From: Elaine Walby <Elaine.Walby@arun.gov.uk> **On Behalf Of** Planning
Sent: 12 March 2026 10:15
To: Planning.Responses <Planning.Responses@arun.gov.uk>
Subject: FW: Planning application AW/21/26/HH

Site address
22 sefton avenue aldwick PO21 3BN
Proposed side dormer and partial garage conversion

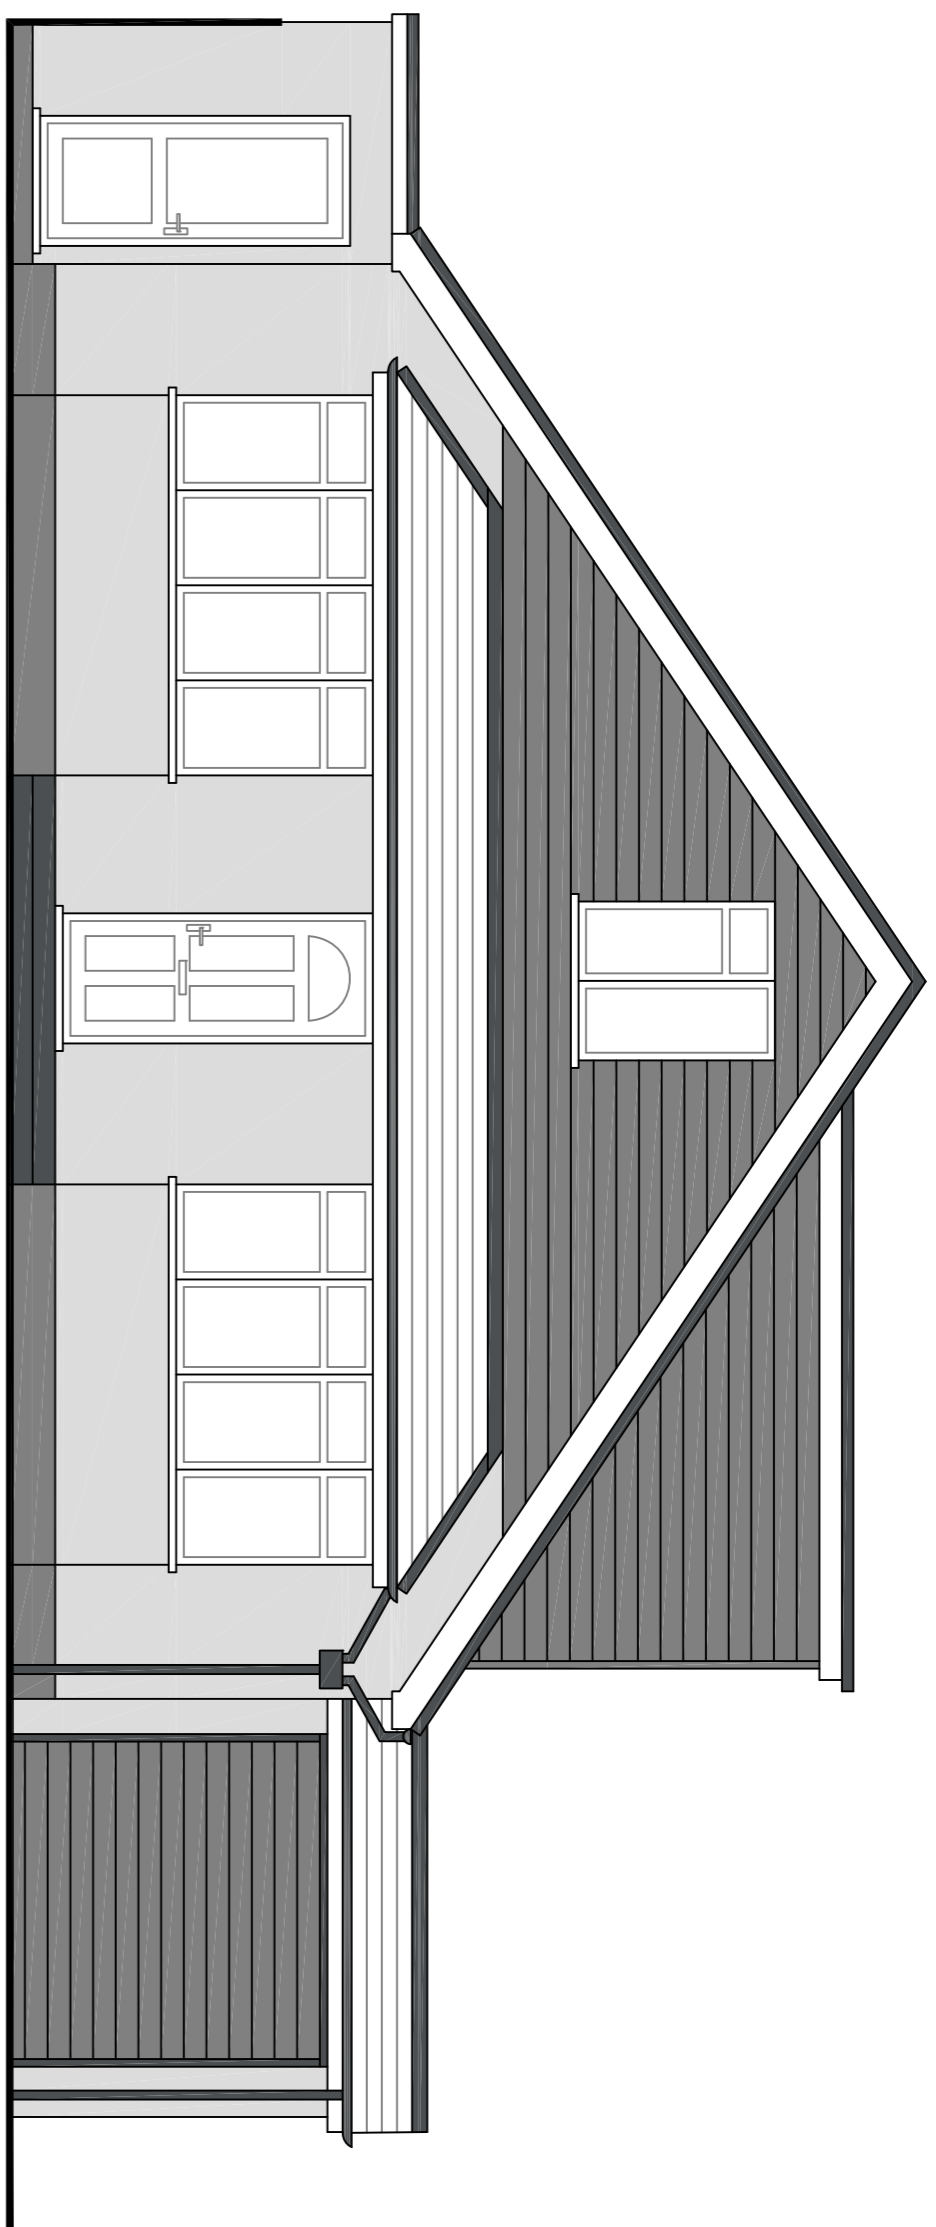
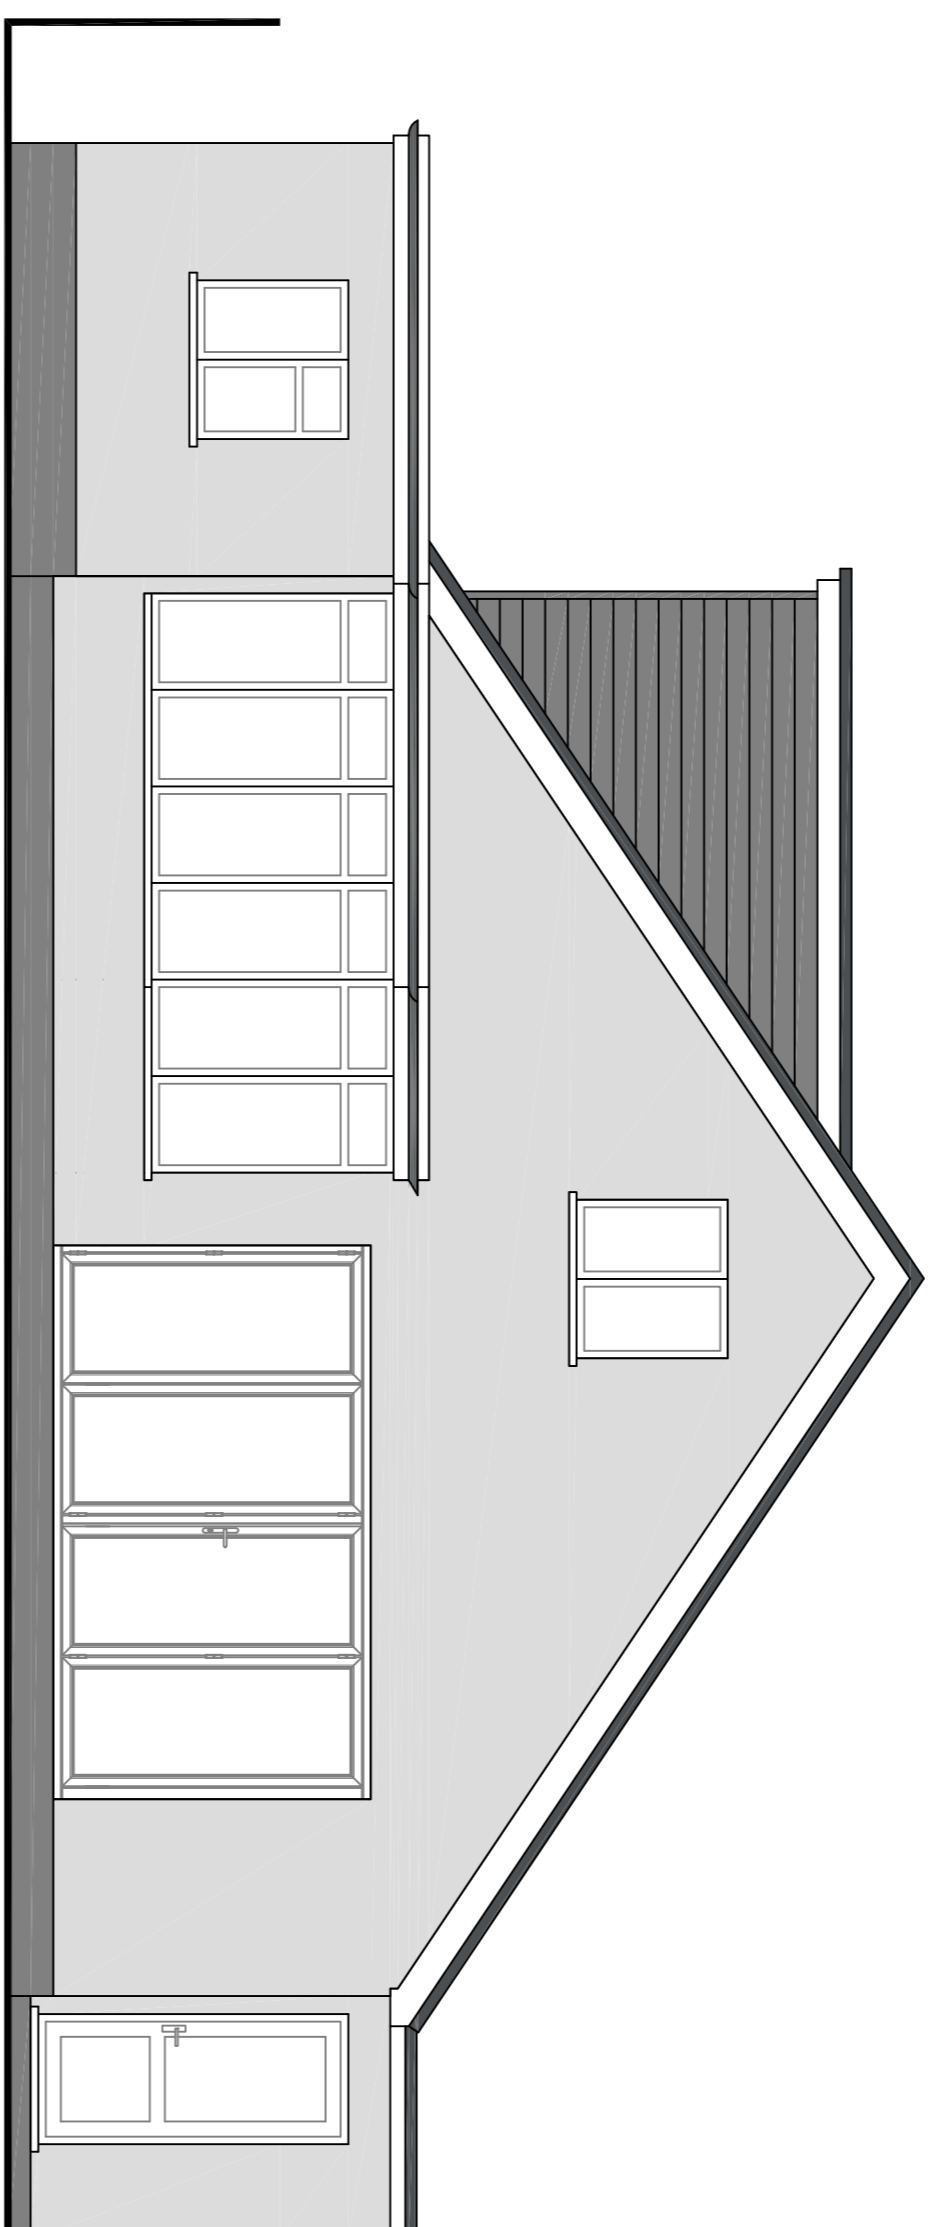
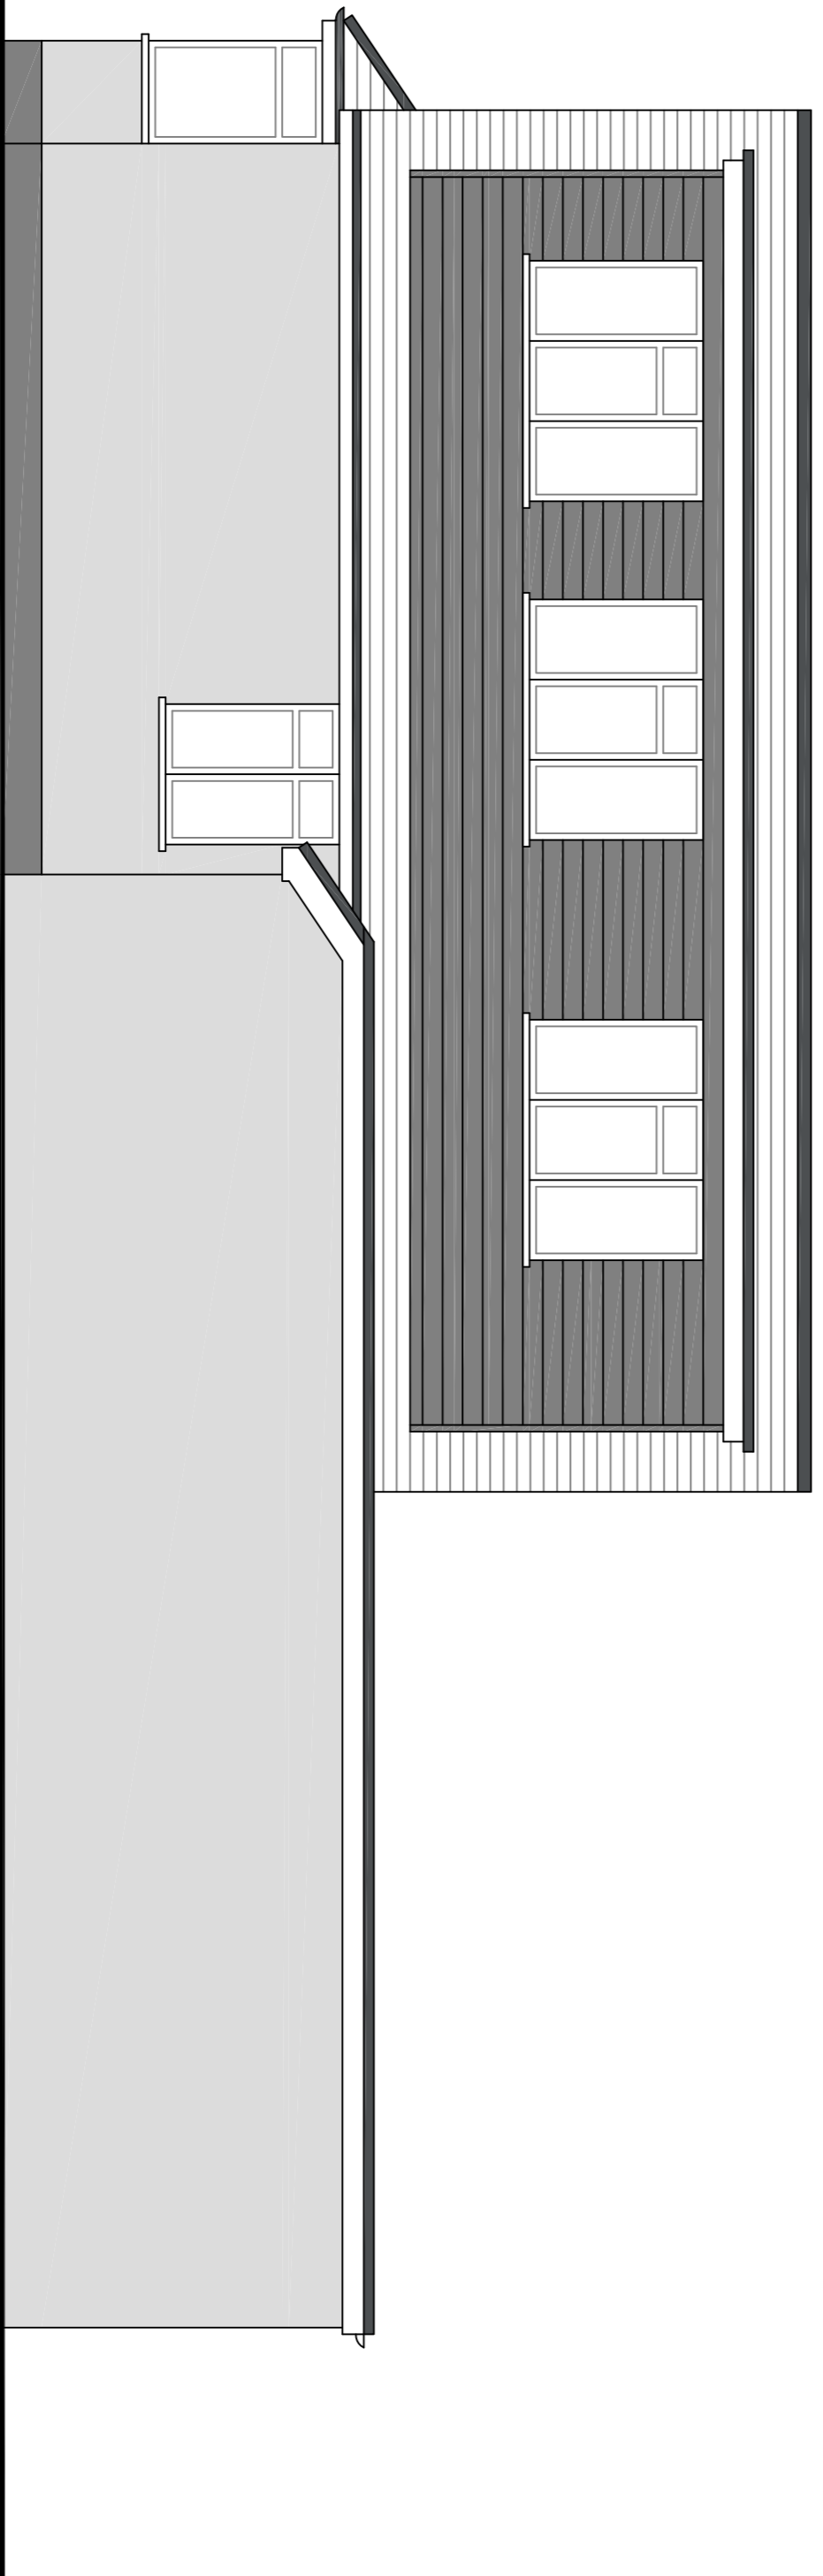
As mentioned in the comments made on the portal, we have no objection to the proposed works but are concerned about our privacy with the windows of the new dormer over looking into our garden and lounge, so would request obscured glazing.

We do have an existing velux in our roof above our kitchen adjacent to the proposed works.
